**Christina Stacey - RE: 117 Preble St., BP#2016-00172 Interior demolition, etc**

**From:** Jeanie Bourke [<mailto:JMB@portlandmaine.gov>]  
**Sent:** Thursday, January 28, 2016 1:16 PM  
**To:** Matthew Gagnon  
**Cc:** Building Inspections  
**Subject:** 117 Preble St., BP#2016-00172 Interior demolition, etc

In looking at the plan files submitted for this permit, it appears that a significant portion is for work beyond the scope of the interior demolition work.

D1.2

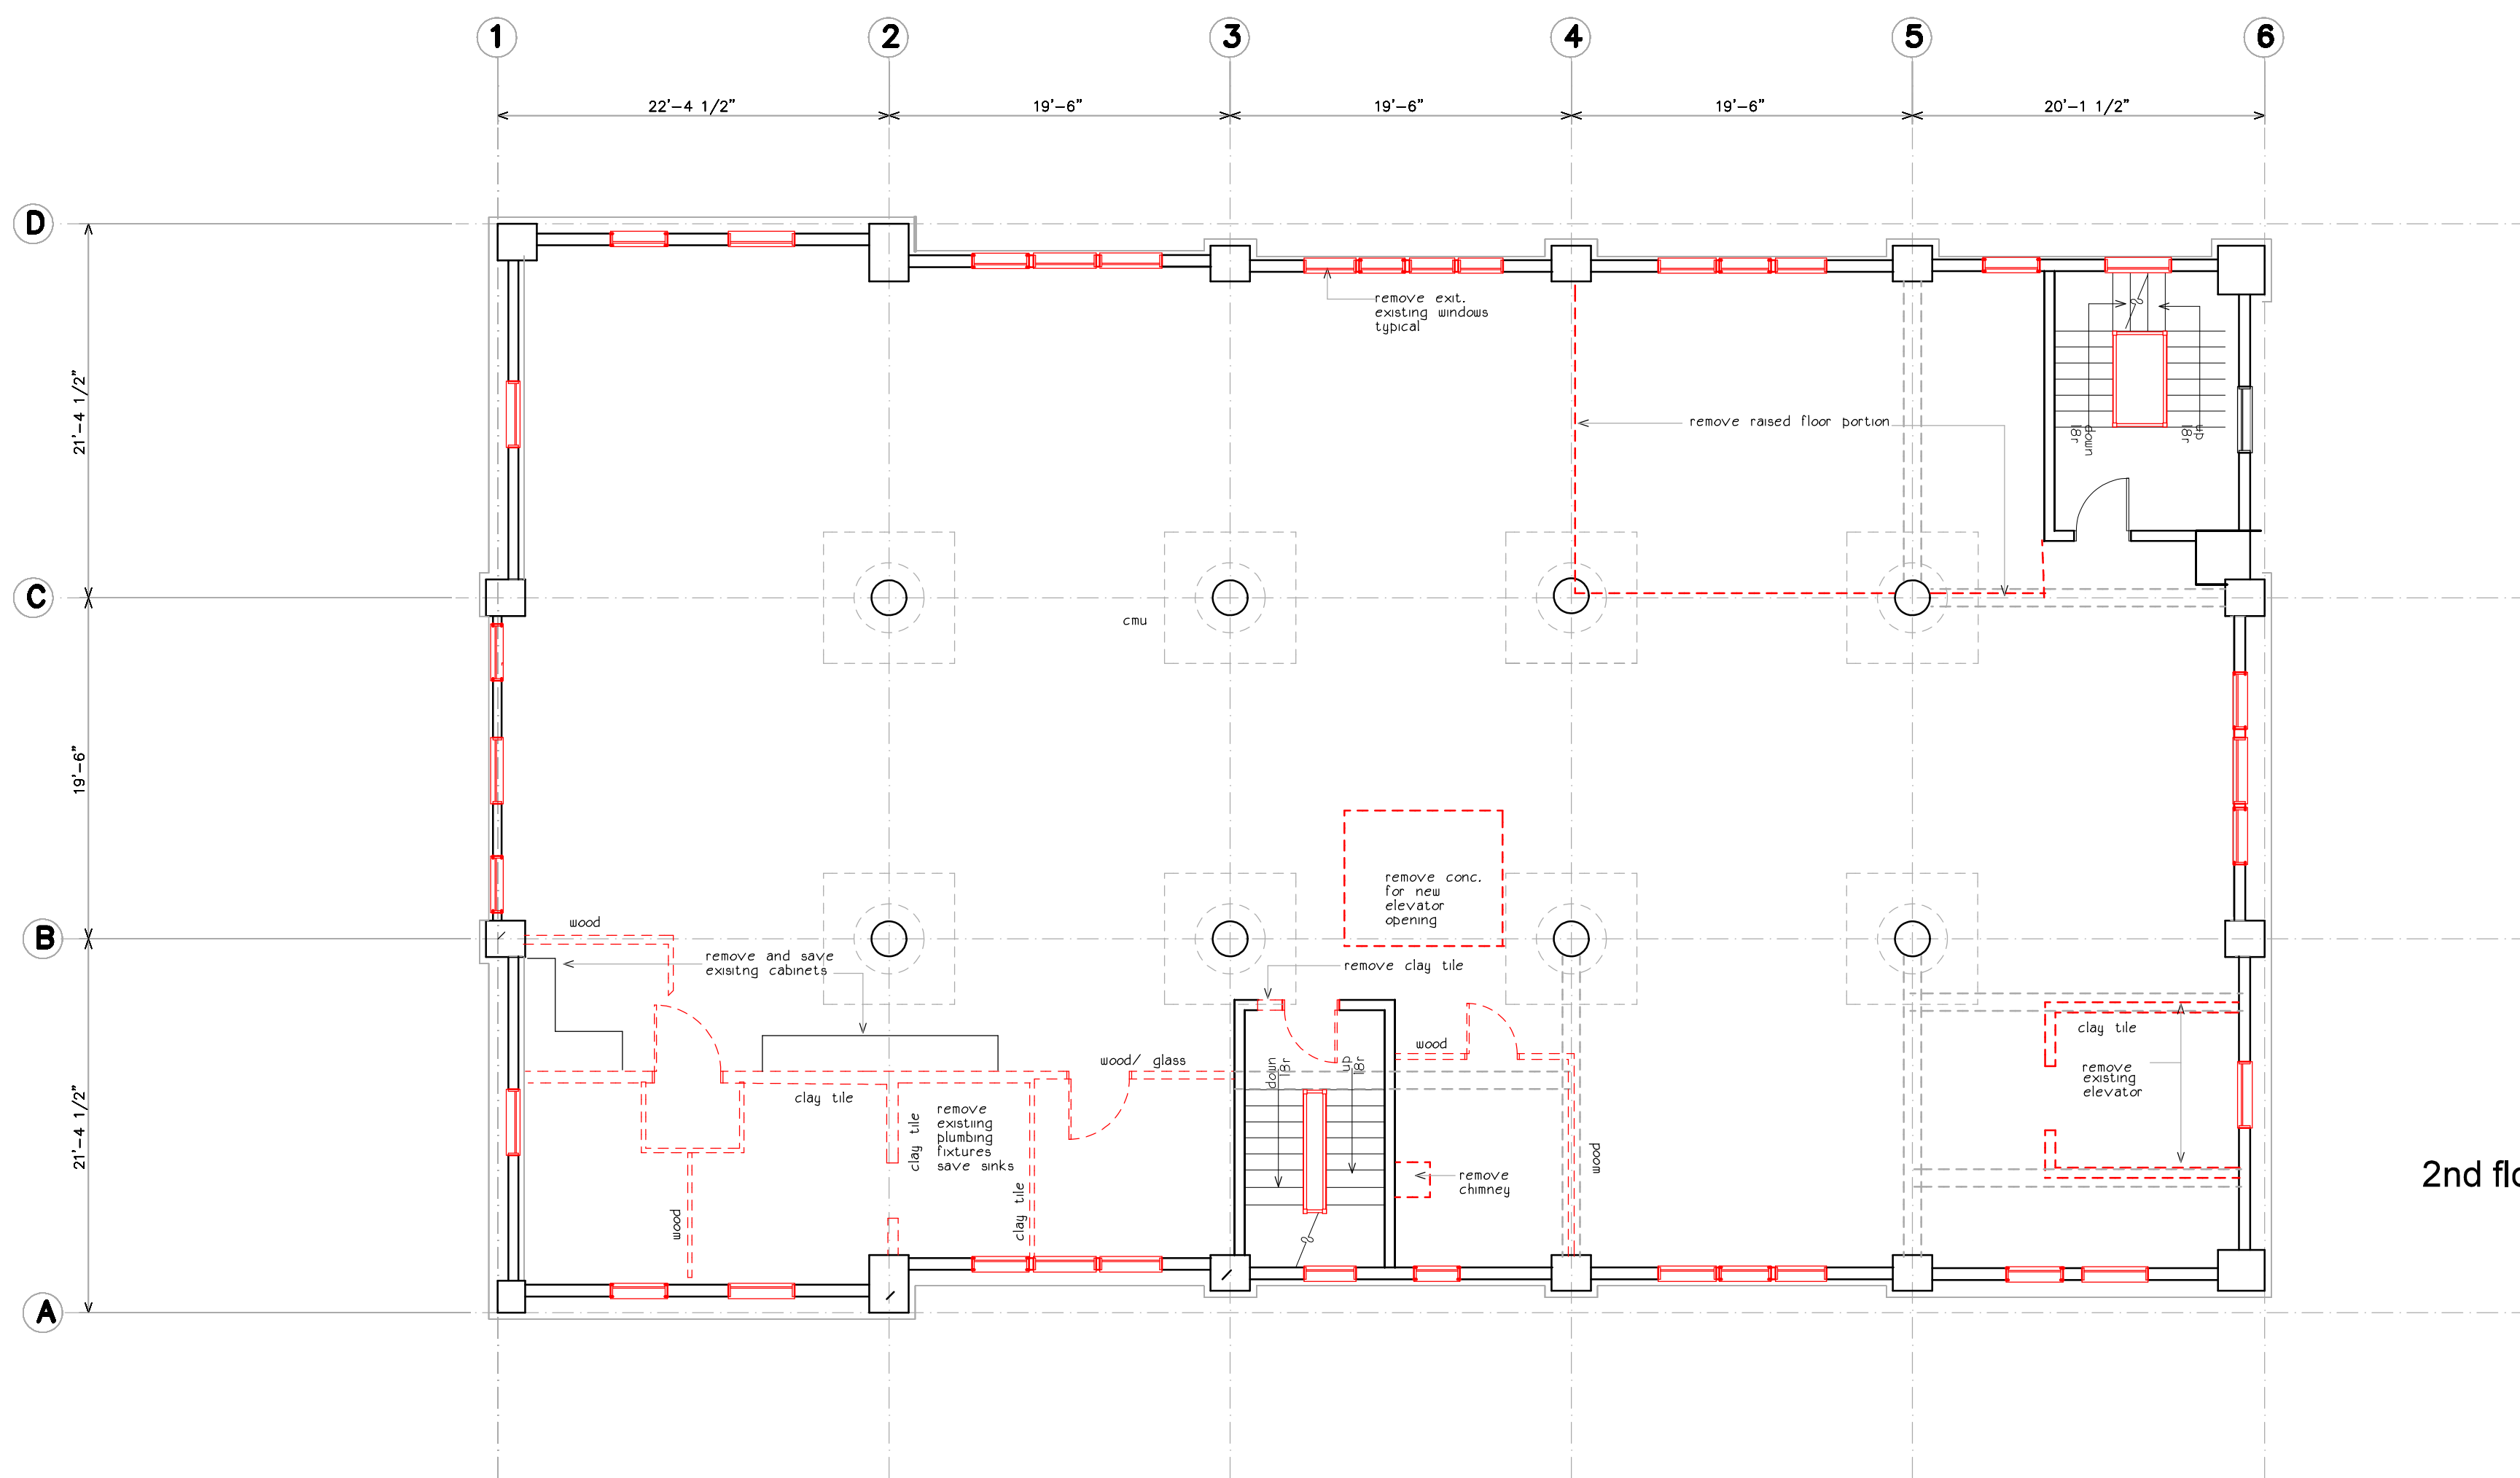
Thanks for pairing down the plans set for this permit. My email was a bit misleading as there is additional work beyond interior demo, like re-roofing and window replacement. The window locations are shown on the demo and elevation plans, however I do not see that the new window details have been included. Correct me if I'm wrong, but I understood that windows will be installed on this permit as well. I think you also have some roofing plans and details that should also be part of this set.

We are looking to get the demolition started at this point and are fine with eliminating the Roof/Windows for this permit. We are in hopes to apply for full permit in the near future so, please delete the roof and windows part of the application. Let me know if you want me to re-issue the application without.
